DEVELOPMENT REVIEW BOARD  
TRANSPORTATION DEVELOPMENT

DRB Project Number: 2018-001579  
Hotel at Winrock Mall

SUBJECT: Plat, Site Plan

DATE: January 8, 2020

PROJECT TITLE HOTEL SITE DETAILS WINROCK TOWN CENTER ALBUQUERQUE NEW MEXICO	PROJECT MANAGER STEPHEN DUNBAR, AIA	JOB NO. WIN-EJ	DRAWN BY S-J
SHEET TITLE SITE DETAILS

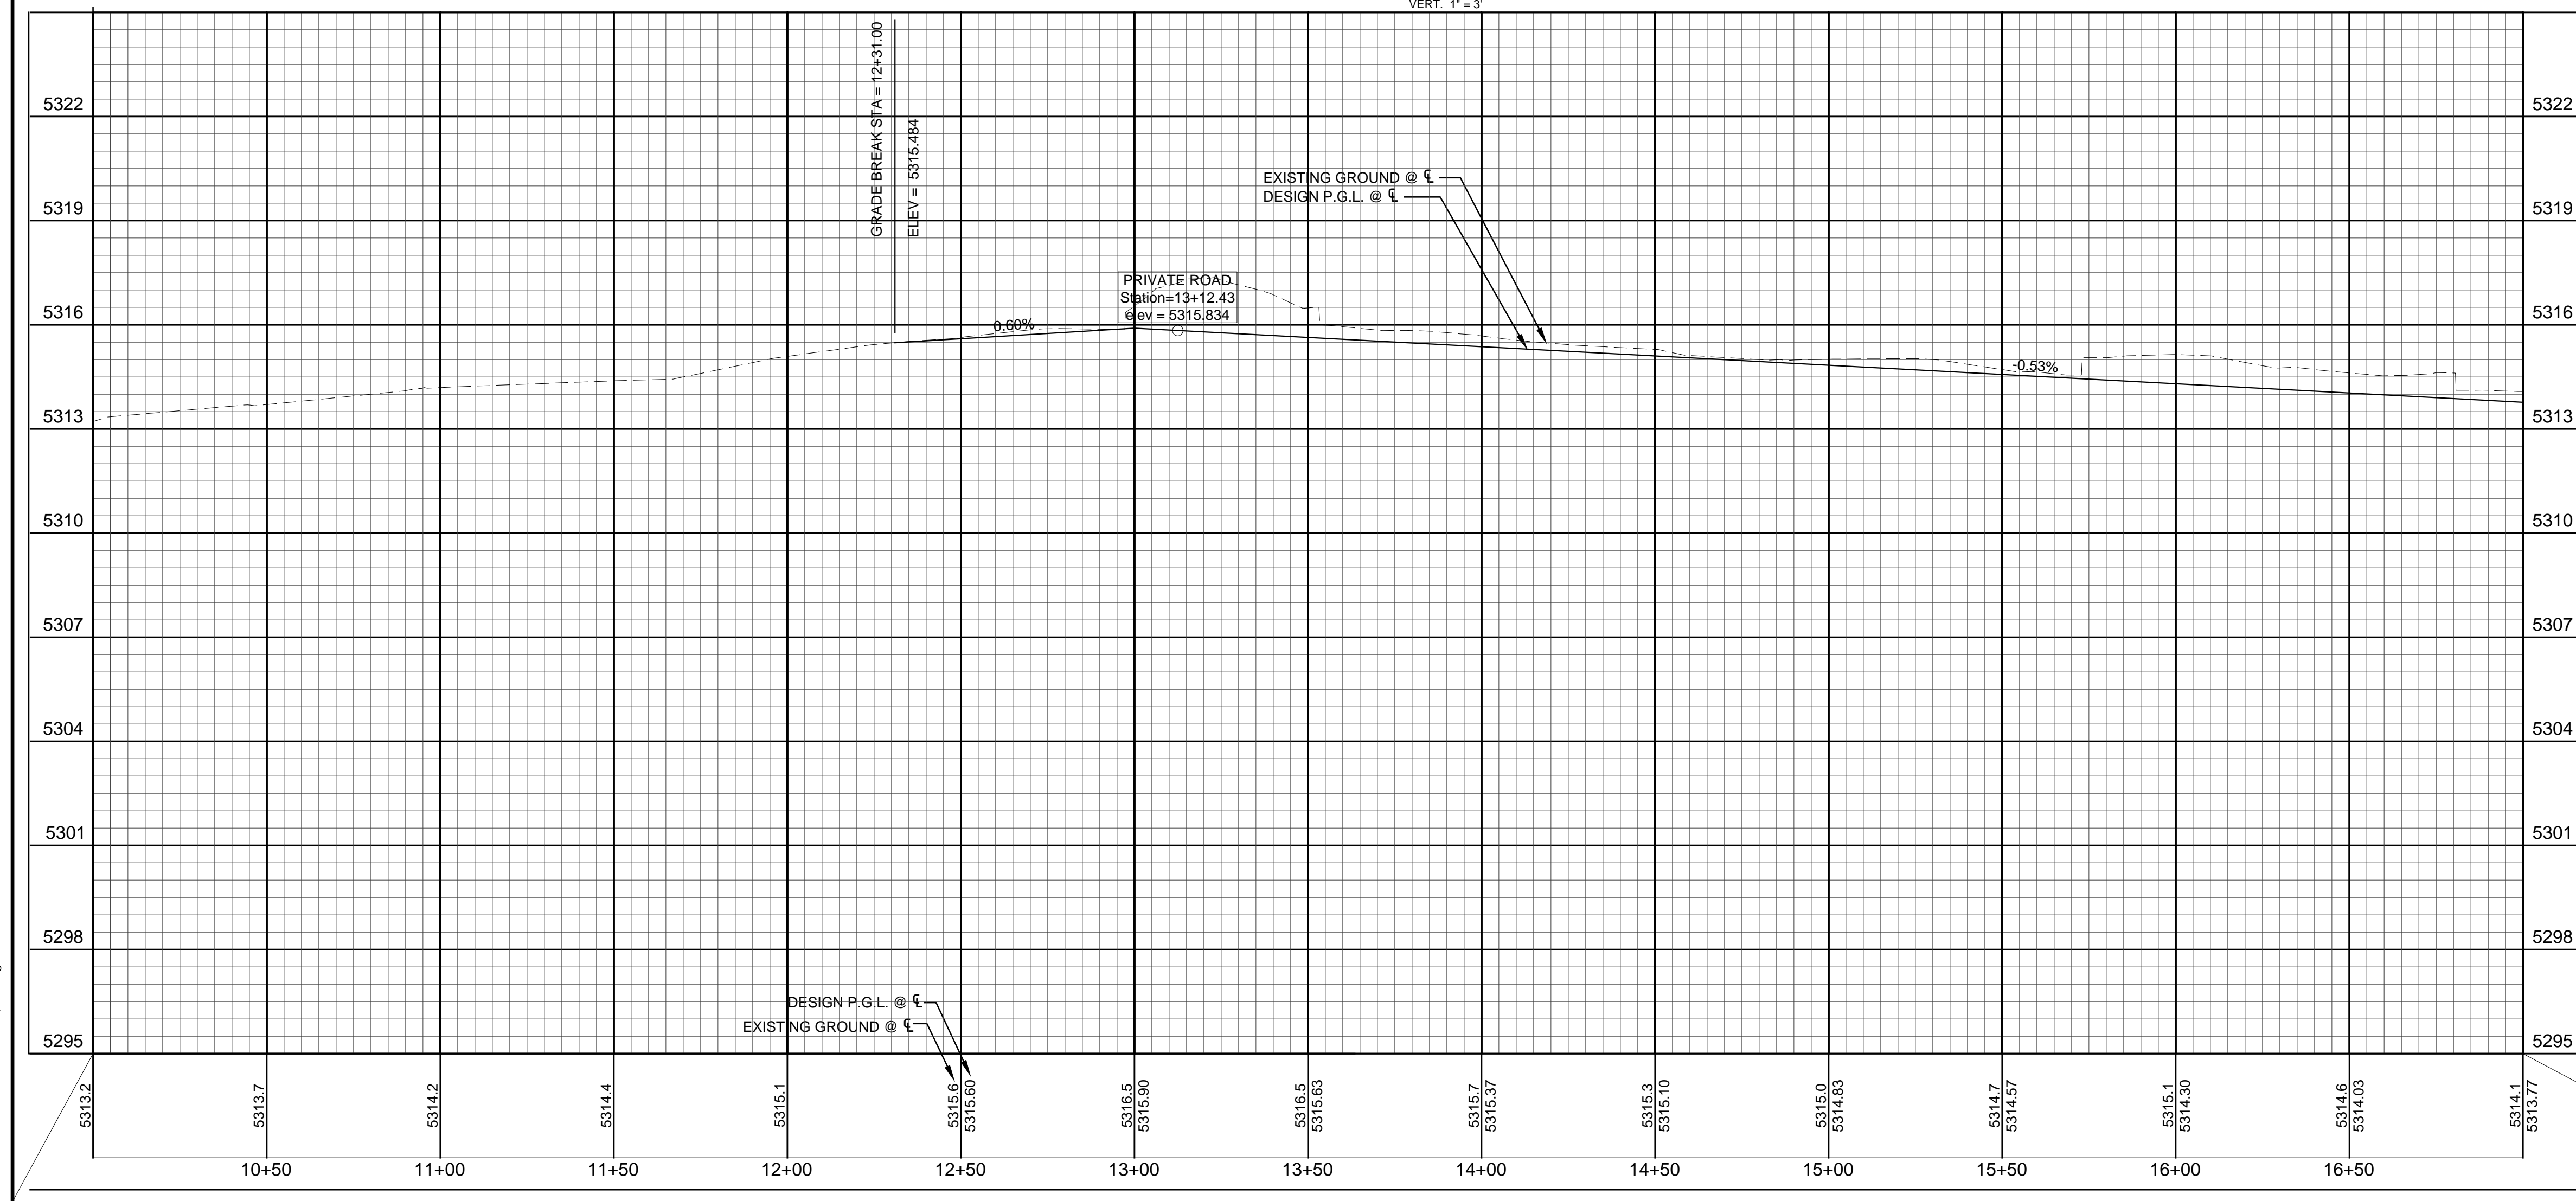
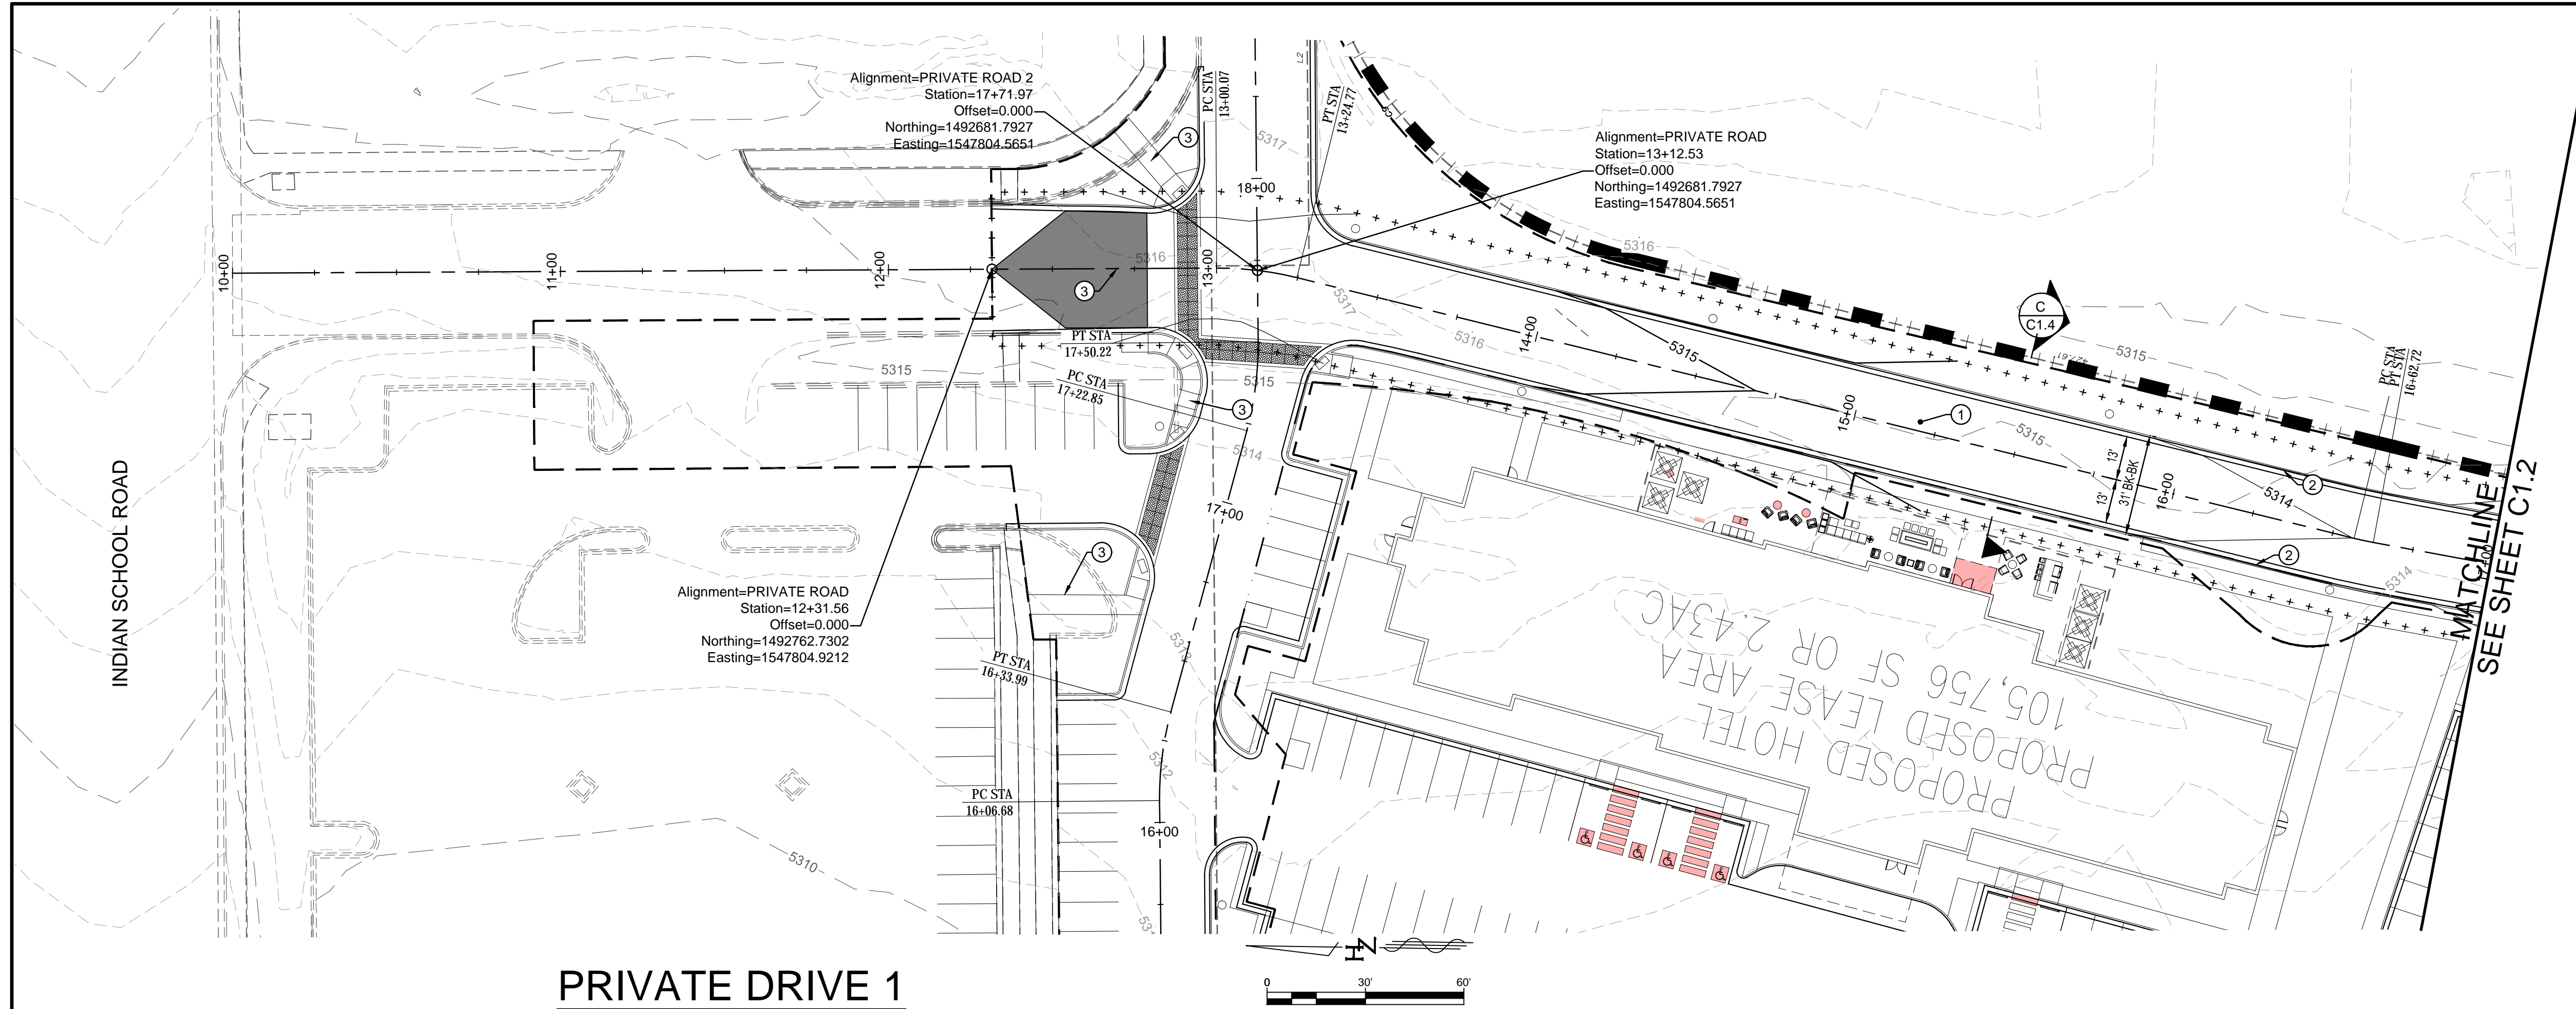
7. For further clarification on the detail sheet for the street crosswalk, specify "#4 rebar @ 12".
8. On the profile sheets, add "Match existing roadway" notes, and label grade elevations at all grade breaks. For the stationing, label bearings on station line, tie stationing to benchmark or plat corner, and label "centerline" if the stationing defines the centerline of the roadway. Label cross-section transitions as needed.

Design Review Committee	City Engineer	Mo./Day/Yr.	Mo./Day/Yr.
City Project No.	Zone Map No.	Sheet	Of
XXXX.XX	J-19	C1.1

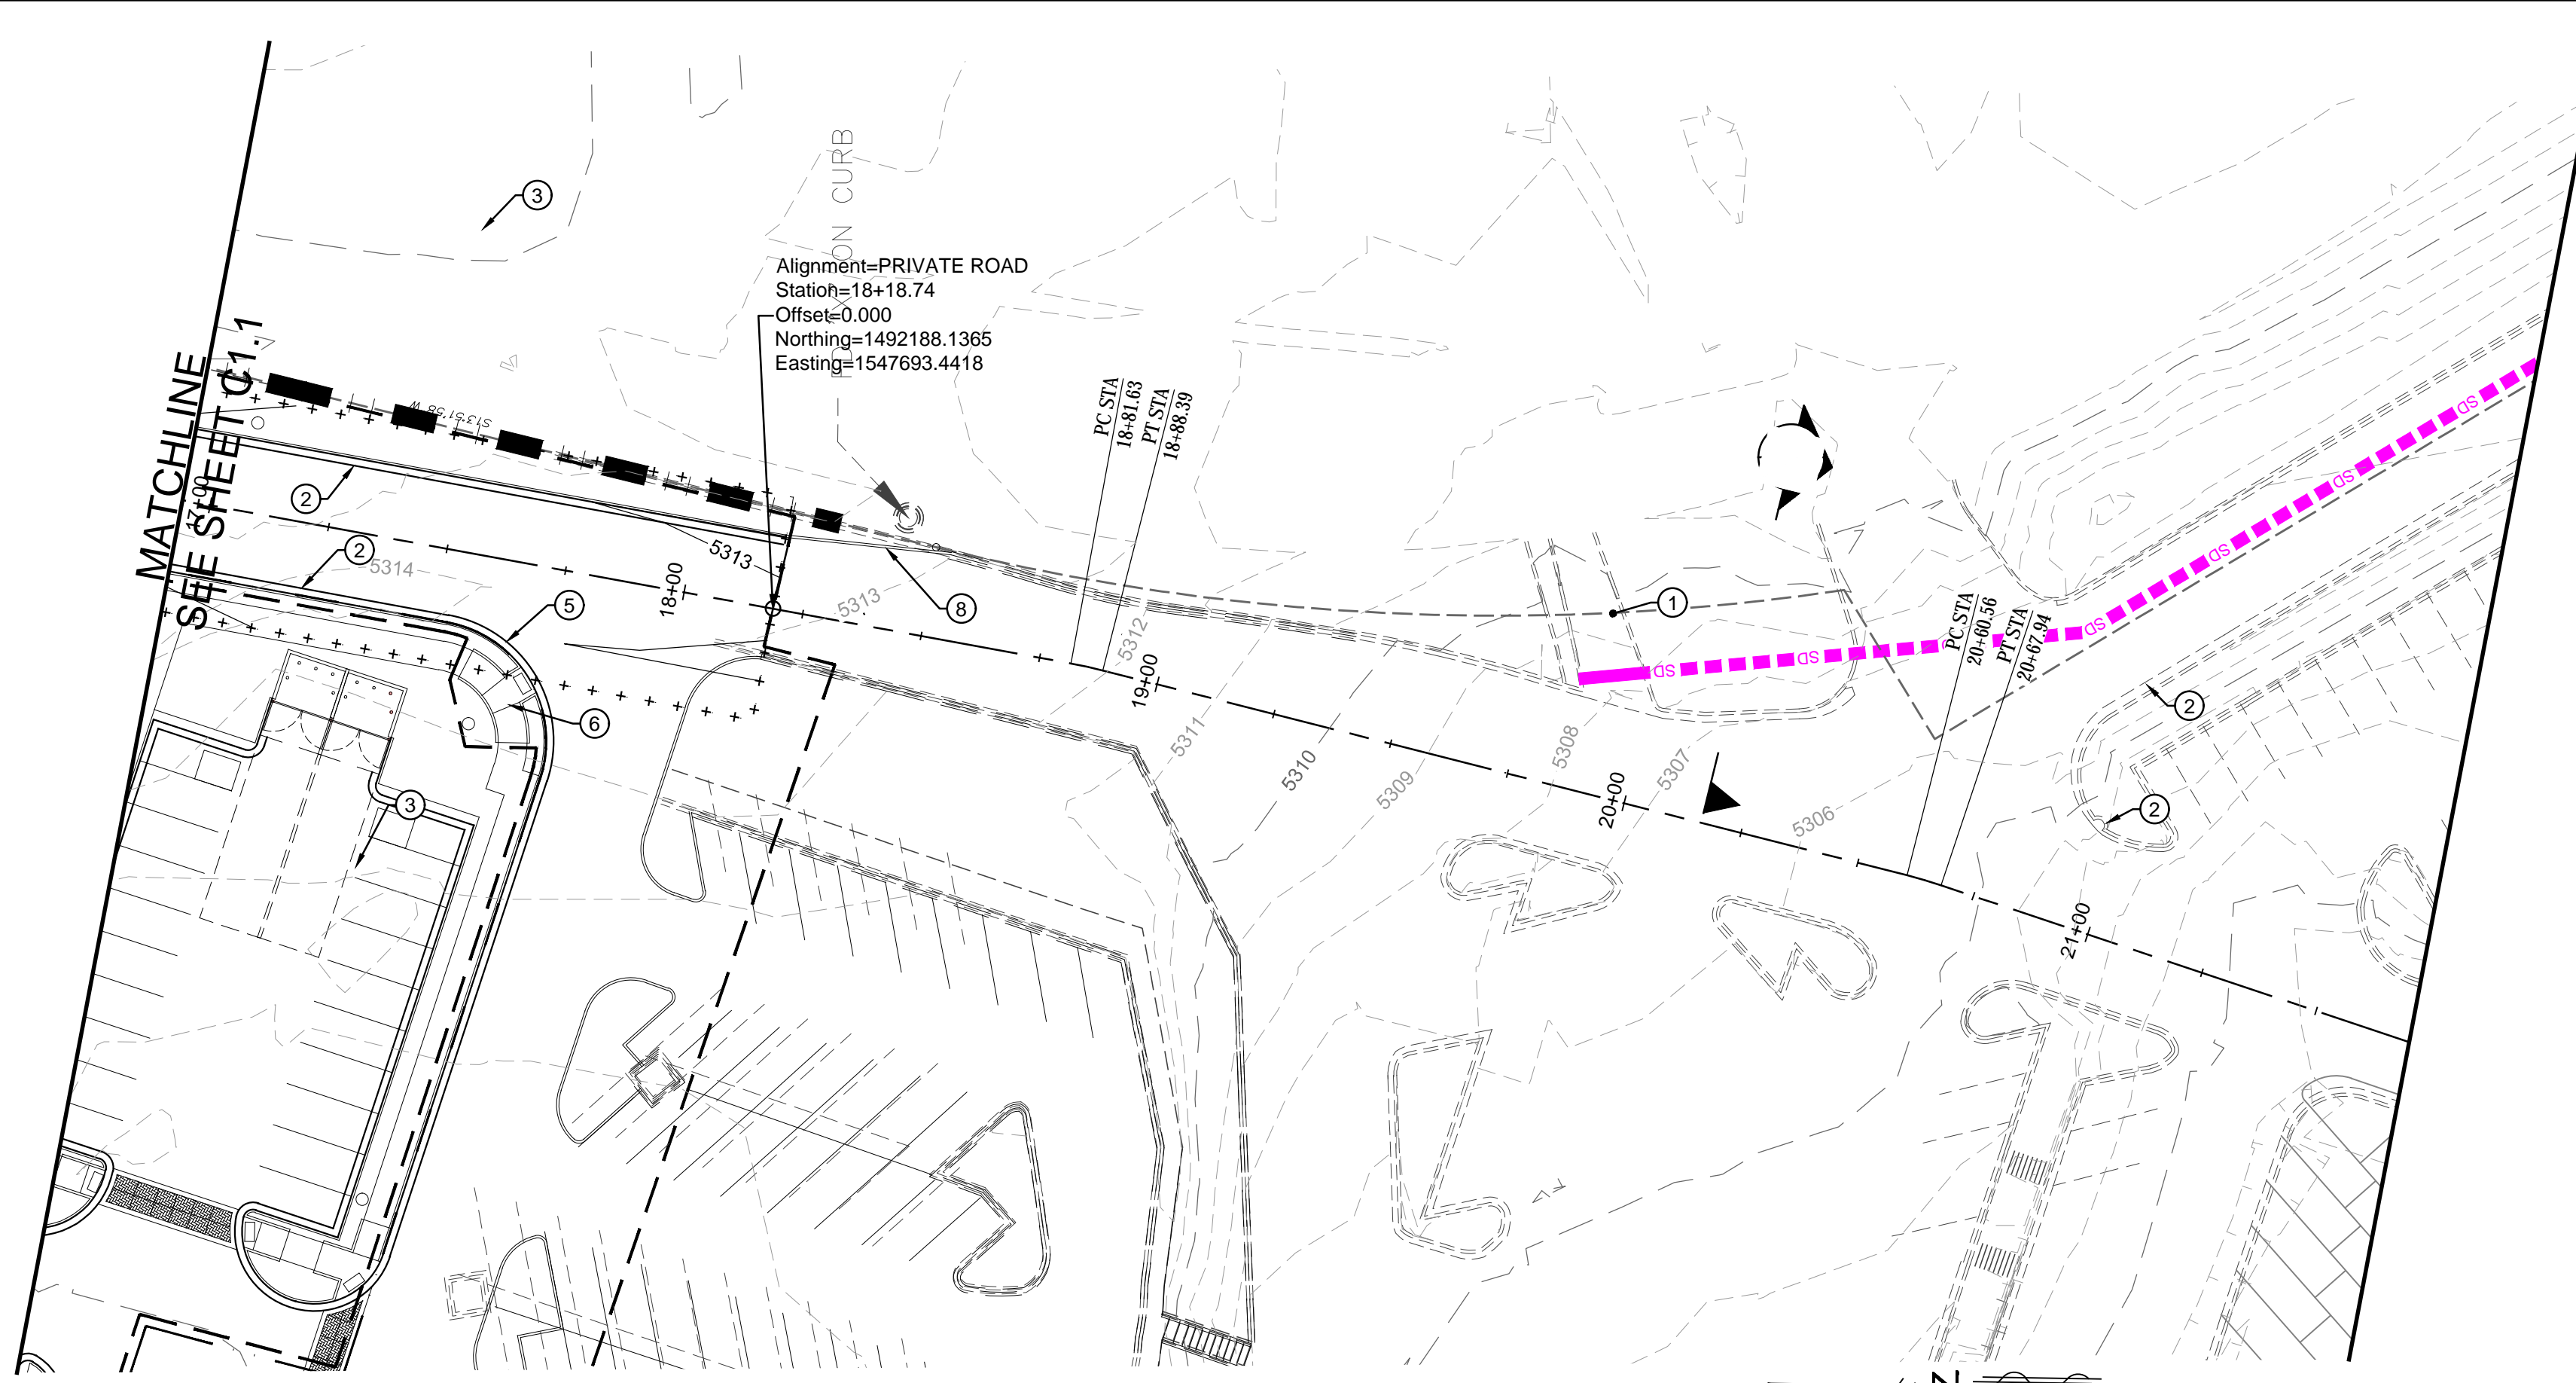
11. On Sheet C1.1, there is a stray sidewalk note shown in the middle of the private roadway.
